Reference No:	2026/62/91559/W
Site Address:	Castle View House, New Mill Road, Wooldale, Holmfirth, HD9 7LT
Description:	Raising rear decking by up to 1050mm, new bi-fold doors to master bedroom. repointing stonework and quoins, installing metal and glass balustrade to rear of decking, replacement of all external windows and doors, replacement of existing sliding electric entrance gate and installing 600mm high metal railing to boundary wall
Recommending Officer:	Joshua Merriman

Officer Report – 2026/91559

Proposed South West Elevation
1 : 100

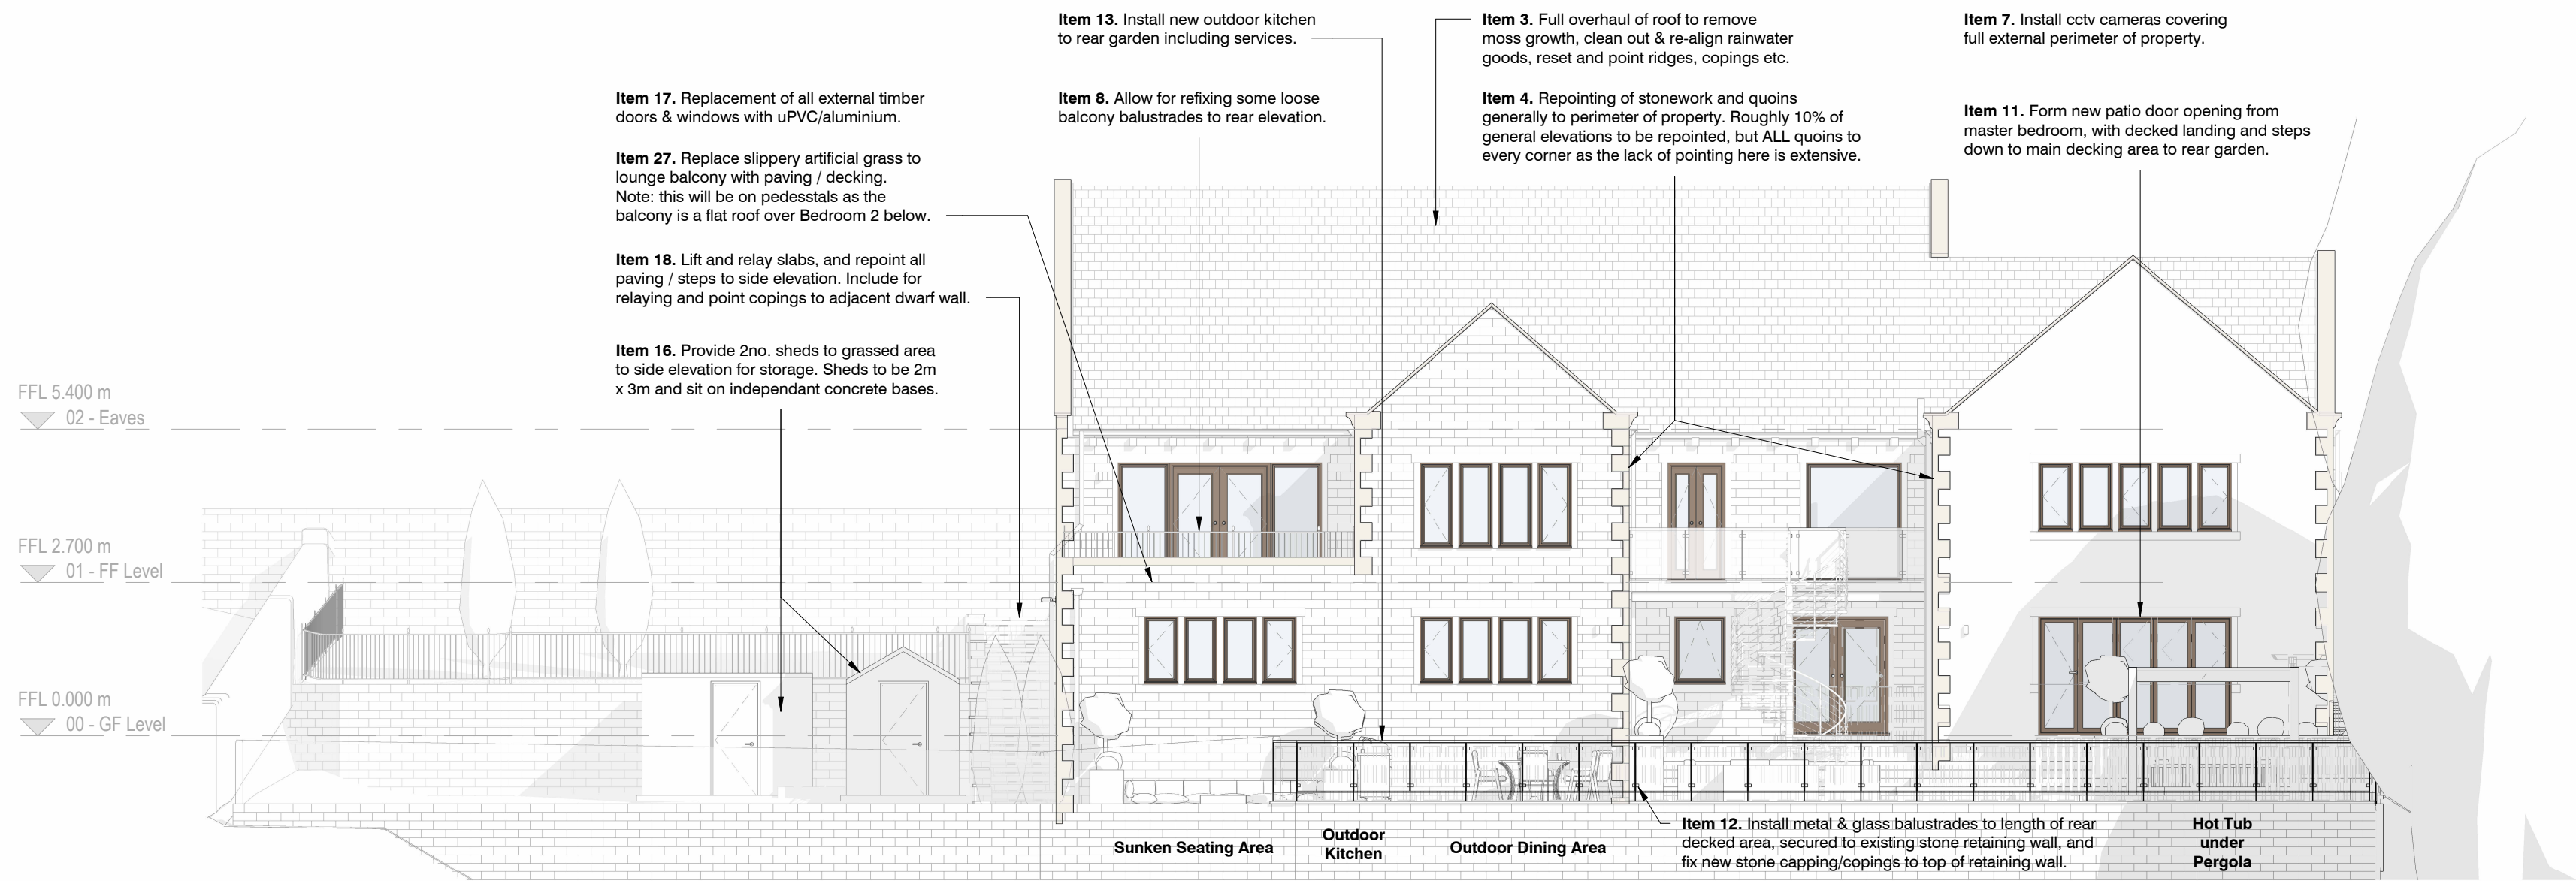
As the raised rear decking, bi-fold doors to master bedroom, and metal and glass balustrades will be located to the rear of the property and not visible from the street scene, it is considered that these aspects of the development will have no significant impact upon the visual amenity of the host property or surrounding area.

The raised rear decking, bi-fold doors to master bedroom, and metal and glass balustrades will face West, onto a heavily natural screened area dropping significantly in slope, therefore, no significant overlooking potential or privacy impacts are considered to be derived from these alterations as they would not significantly alter the overlooking potential that is currently existing from the rear of the property.
